WEST SUSSEX COUNTY COUNCIL CONSULTATION

TO:	Arun District Council FAO: A Gardner
FROM:	Highways, WSCC
DATE:	22 nd November 2018
LOCATION:	Land adjacent to 4 Gladstone Cottages, Water Lane, Angmering, BN16 4EL
SUBJECT:	A/146/18/PL Construction of new semi-detached dwelling extending existing terrace of cottages.
RECOMMENDATION:	☒ Advice ☐ Objection ☐ Modification ☐ No Objection ☒ More Information ☐ Refusal
£106 CONTRIBUTION TOTAL:	£N/A

Proposed Site Plan (1:100)

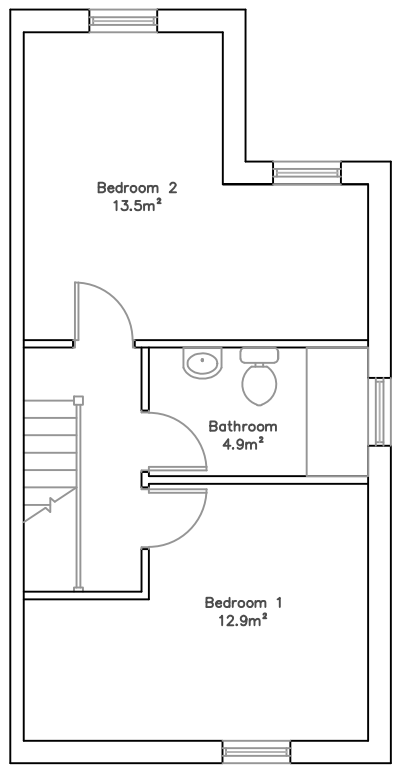
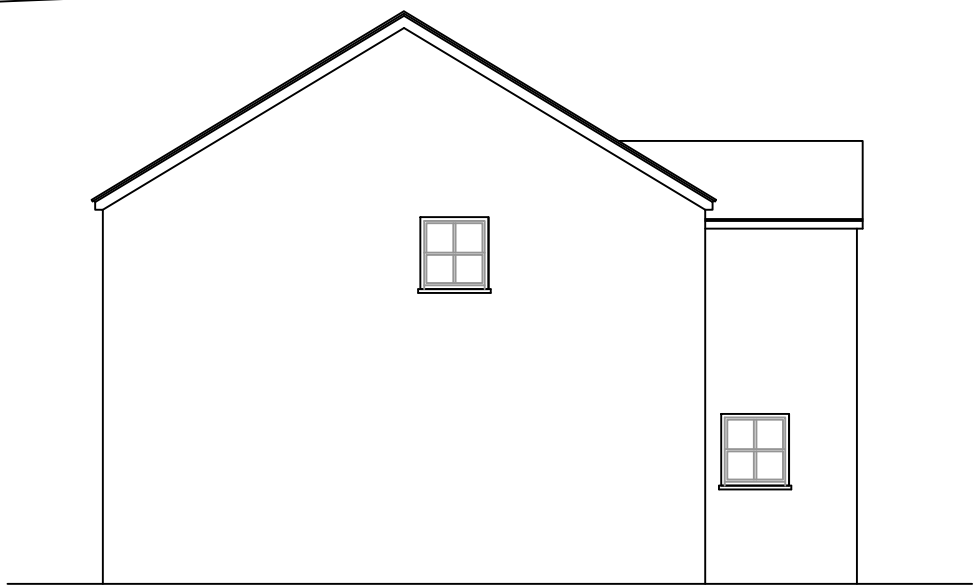
From an inspection of the plans the proposed crossover will be approximately 4.9m wide to facilitate off-street parking for two cars side by side, one allocated to the new dwelling and one to the existing. On the basis of one space being allocated for the new dwelling the WSCC Car Parking Demand Calculator estimates a demand for two spaces. A turn on site would be preferred however the LHA acknowledge that the existing parking has limited space for this and has been operating without evidence of highway safety concern. Furthermore, there is the benefit of providing an opportunity to remove a vehicle that would otherwise be parked on the highway in a location where the existing practice is on-street parking by residents of adjoining properties which results in a noticeable narrowing of the existing available carriageway space.

The existing crossover would require to be closed off and the kerb reinstated. Vehicular visibility has not been demonstrated for the new access point on to the classified public highway. Manual for Streets sets out a requirement for a stopping sight distance of 43m for vehicle speeds of 30mph. This should be taken from 2.4m back into the centre proposed access point and extend to the nearside carriageway edge in either direction. If the full splay cannot be achieved without passing through third party land then the applicant should demonstrate that the new access point is no worse than the existing by providing maximum achievable visibility splays for both and will assess the highway safety merits of the scheme on this basis.
